From: Planning
Sent: 03 October 2022 14:20
To: DC Support
Subject: FW: 22/01682/F - Land North Of Manor Farm Noke

Land North Of Manor Farm, Noke.

Development of a ground mounted solar farm incorporating the installation of solar PV panels, associated infrastructure and access, as well as landscape planting and designated ecological enhancement areas.

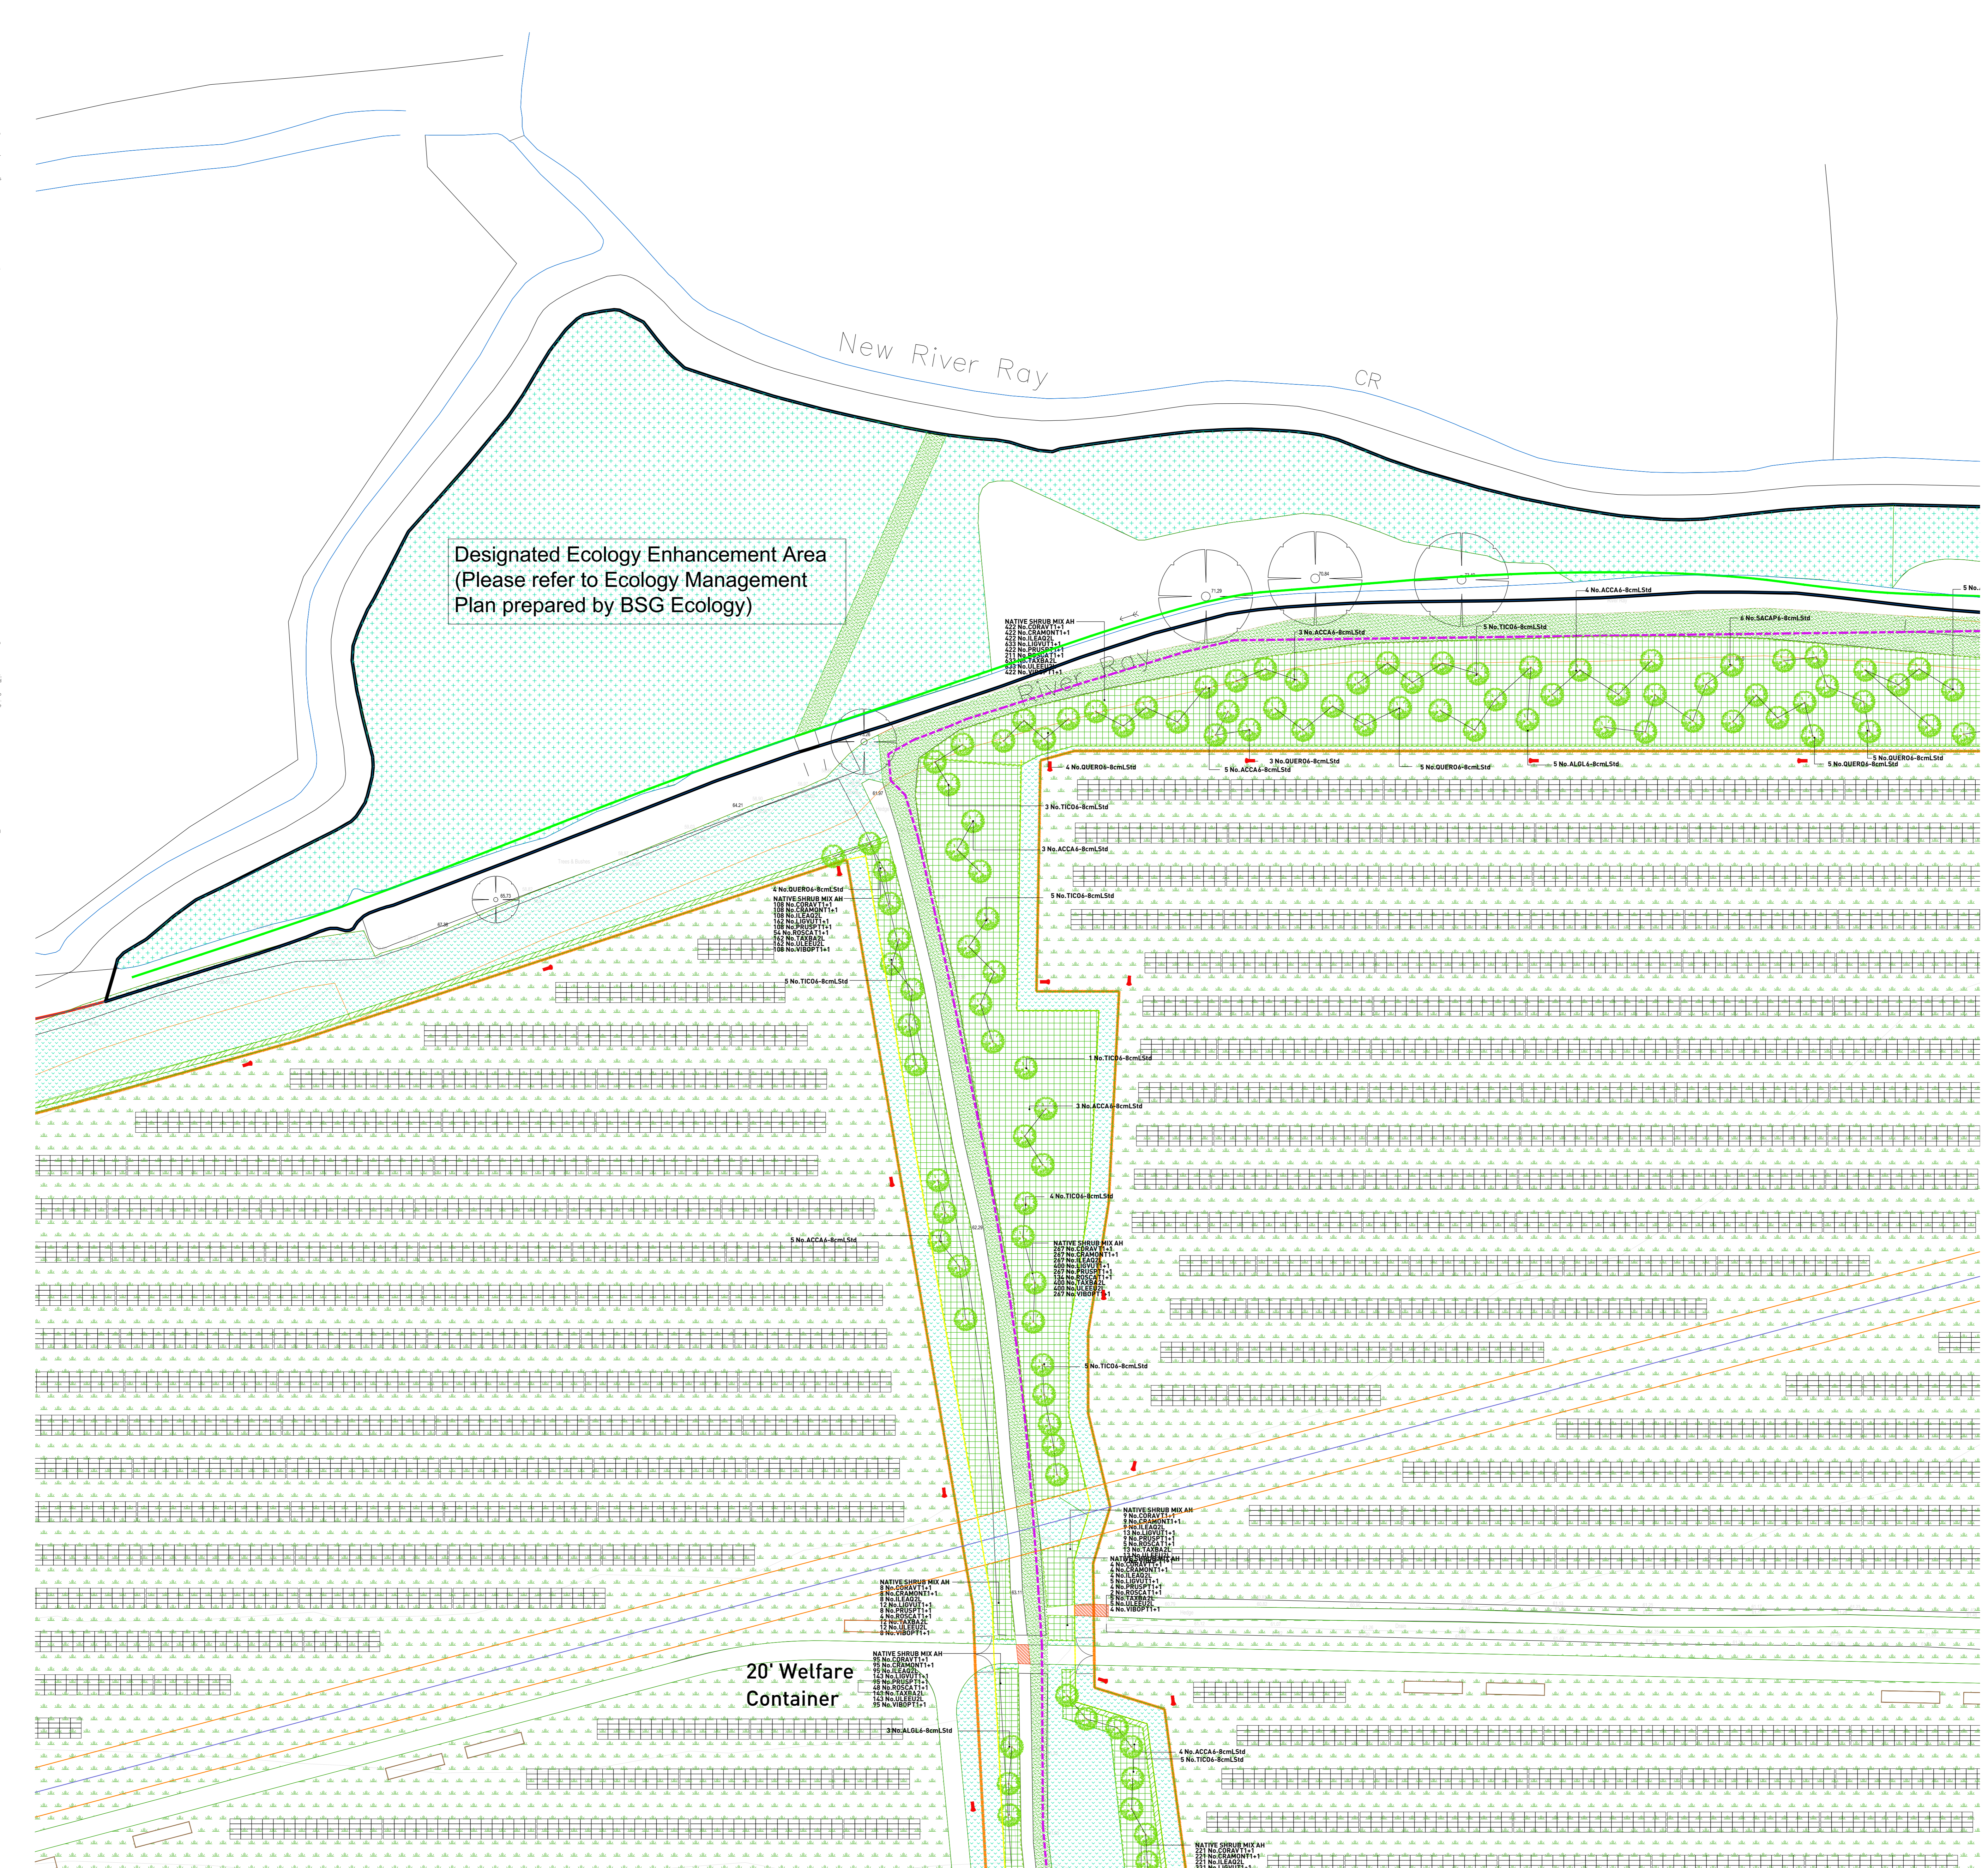
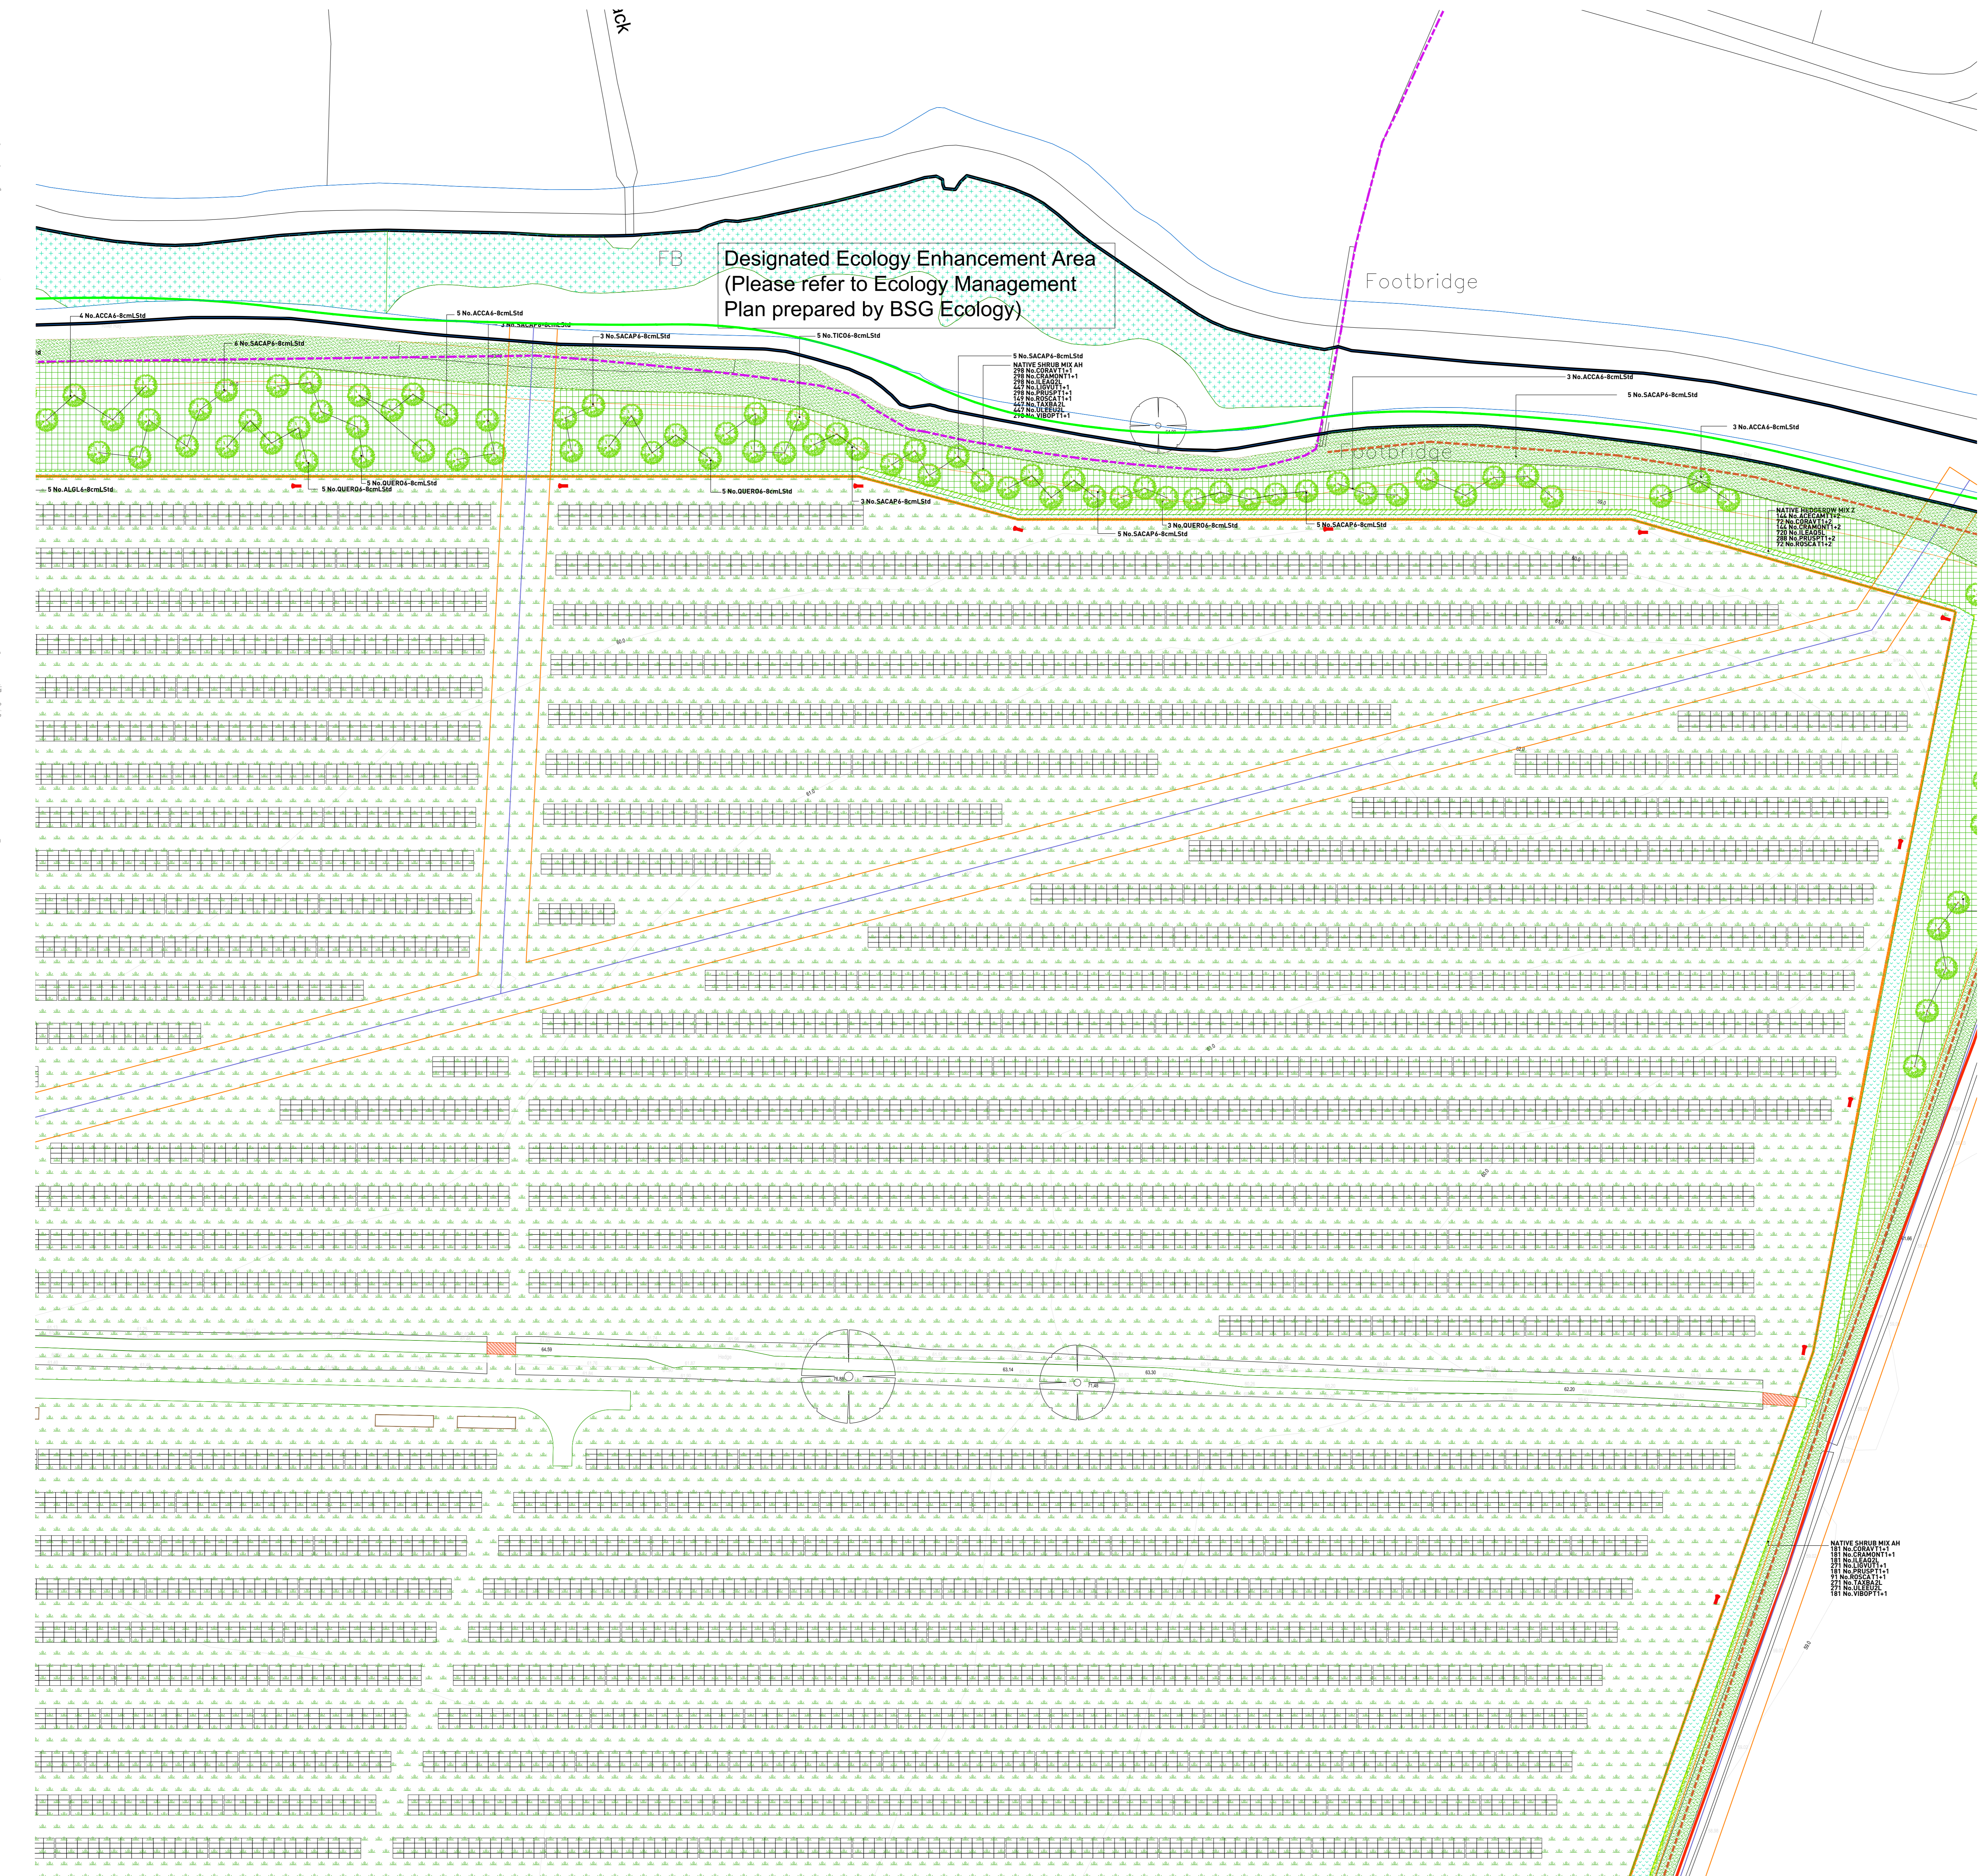
Although the landscape masterplan is favourably comprehensive and offers a good level of detail (as shown in the supporting Soft Landscape Proposals sheets 1-7) in providing a screening by the 15th year of completion it would undoubtedly reduce the openness of the Green Belt and constitute encroachment into the countryside, causing significant harm. The application meets a number of the 'very special circumstances' for the need for renewable energy, however the size and magnitude of the application and the visual impact on the Green Belt is still seen as being inappropriate.
